**Consultation Response from KC,
Trees**

2025/91121 St Marys Vicarage, Spen Lane, Gomersal, Cleckheaton, BD19 4LS

Demolition of existing vicarage and erection of 10 apartments

Date Responded: 20/06/2025

Title:
TREE IMPACT PLAN

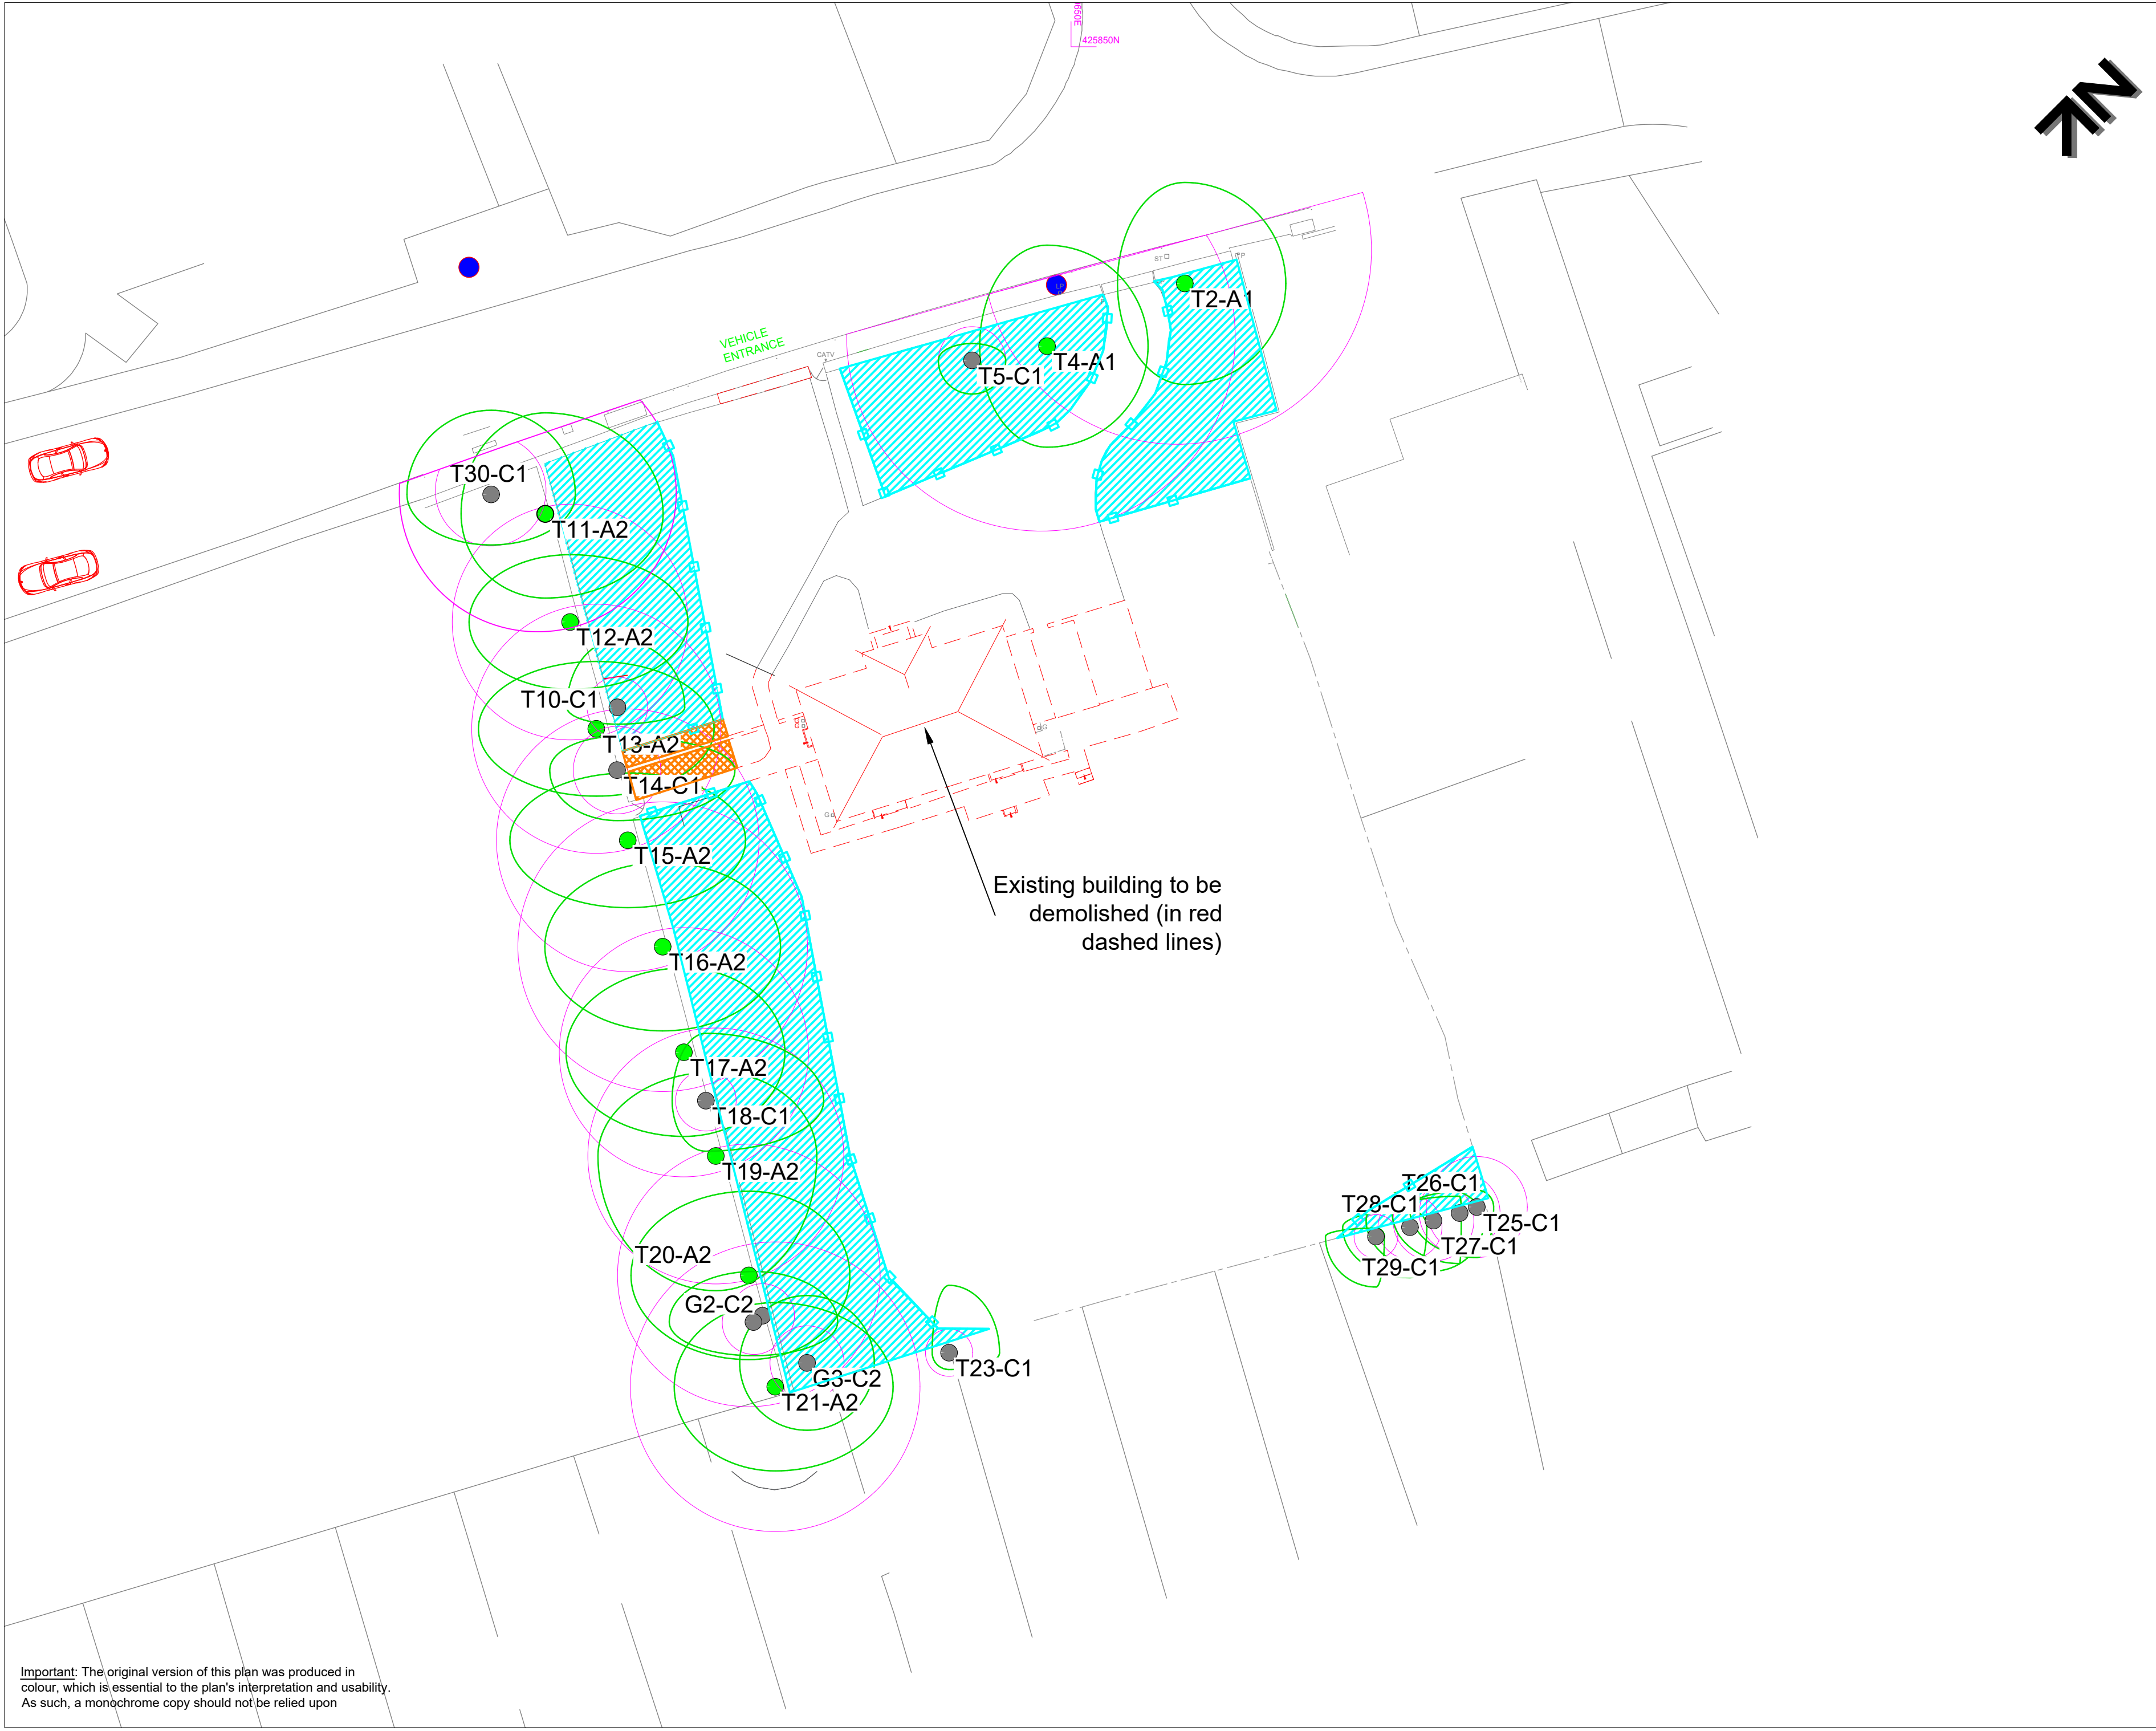
All bar one of the trees on the frontage are proposed for removal, including mature, good quality trees. Most notably, T4 (Category A) and T7 (Category B), both located at the frontage of the site, prominently visible from Spen Lane. This would significantly change the character of the site and the visual amenity value afforded by the trees on the frontage would be lost.

T2 and T11 (both Category A), also located on the frontage, are shown as retained on the Tree Impacts Plan, however due to the development proposals immediately around the trees it is doubtful that they can be retained in this location without detrimental impacts to long-term health (i.e. encroachment of driveway, demolition and relocation of stone wall closer to the stems of T2 and T11, construction of footpath with RPA).

Category C items G1, T9 and T10 are proposed to be removed due to direct conflict with car parking spaces and bike shelters. T1, T3 and H1 are proposed to be removed for the pedestrian access from Spen Lane.

T22(Cat B), two trees within G3 and the entirety of G4 and G5 are proposed to be removed due to direct conflict with the proposed pedestrian footpath along the west boundary. The proposed footpath would encroach the RPAs of all the Cat A, high-value, off-site trees on the Western boundary and slightly encroach into the RPAs of third-party trees on the southern boundary.

Utilities layout was not assessed as part of the submitted AIA. Please note that all utilities must be routed outside of the RPAs of all retained trees.

Methods suggested to reduce impacts to the trees include No-dig construction methodologies for the footpaths and specialist foundations for the proposed bike shelter.
